Recommendation Report for Planning Permission for Works or Extension to a Dwelling

REF NO: AW/357/20/HH

LOCATION: Land Between 8 And 12
10 Wychwood Close
Aldwick
PO21 4DW

PROPOSAL: Outbuilding in rear garden. (This application may affect the setting of the Craigwell Conservation Area.)

FOR MR & MRS HARTLEY		
SITE 10 WHYCHWOOD CLOSE, ALDWICK, WEST SUSSEX		
TITLE PROPOSED GARDEN ROOM BLOCK PLAN		
SCALE 1:500 © A3	DRAWN AH 12/20	DRAWING NO. 01B REV. A

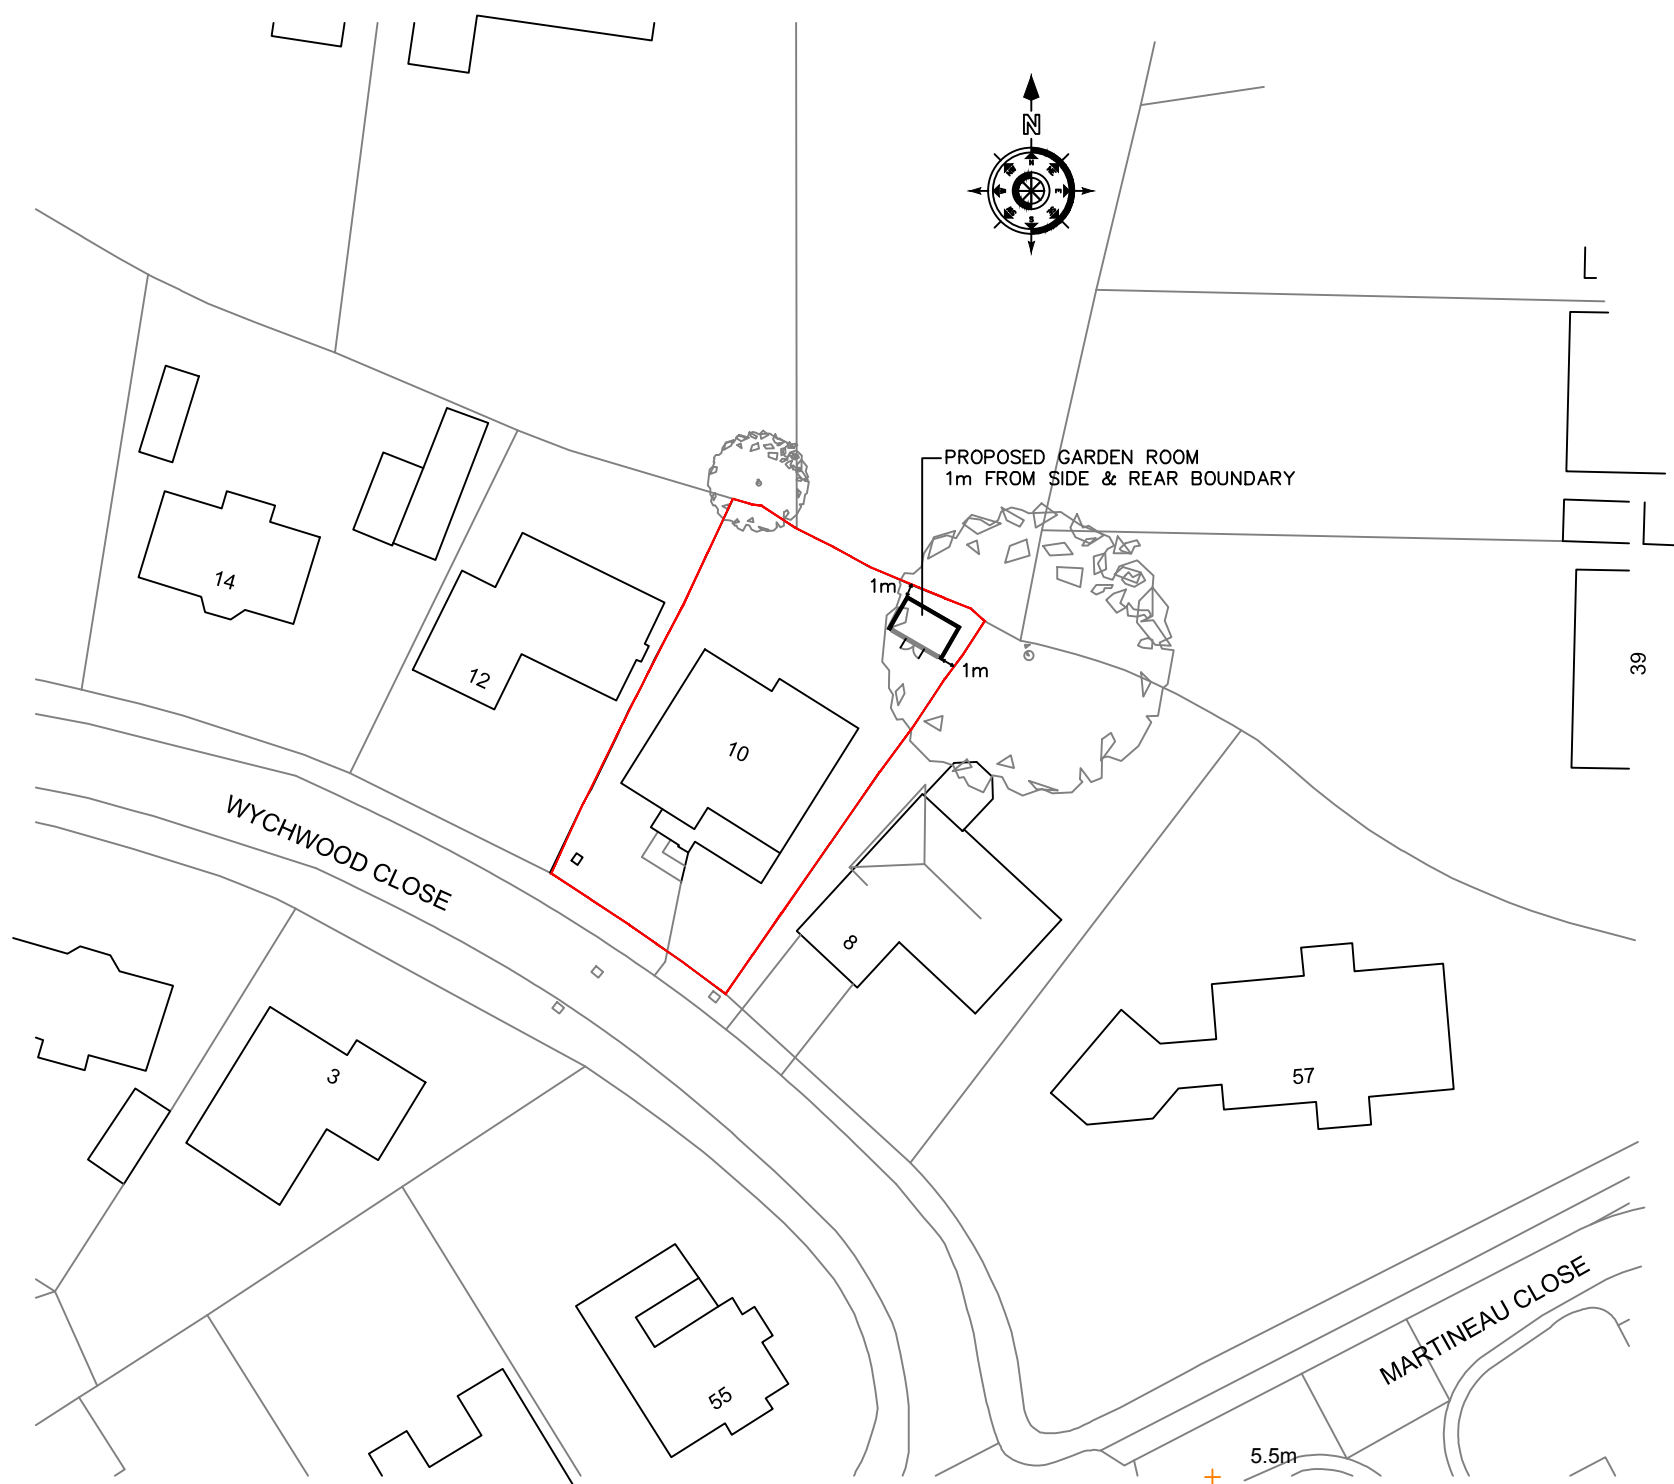
The building footprint appears to be sited within the crown spread and probably within the nominal root protection area (RPA) of an established off-site oak tree. There is potential for damage occurring to those trees during ground preparation and installation of foundations. Furthermore, installation of any services/utilities may need to be routed through RPAs. As it stands an Arboricultural Impact Assessment should be submitted to demonstrate the trees have adequate protection.

The siting of the structure appears to fall within the RPA of an off -site TPO Oak tree and therefore it needs to be ensured that the development would not give rise to harm upon the nearby trees.

The tree officer has been consulted and advised that an Arboricultural Impact Statement and plans should be provided demonstrating whether the structure will harm the RPA and measures that will be undertaken to avoid this.

A pre commencement condition has been included and agreed with the agent for the details to be submitted prior to commencement of the development which seeks to ensure protection of the nearby trees.

- 3 'Prior to commencement of development, details by way of a cross section plan shall be submitted and approved by the Local Planning Authority to ensure that there will be no excavation so as to protect the RPA of a protected Oak tree to the north east corner of the site. The works shall be undertaken in accordance with the approved details.
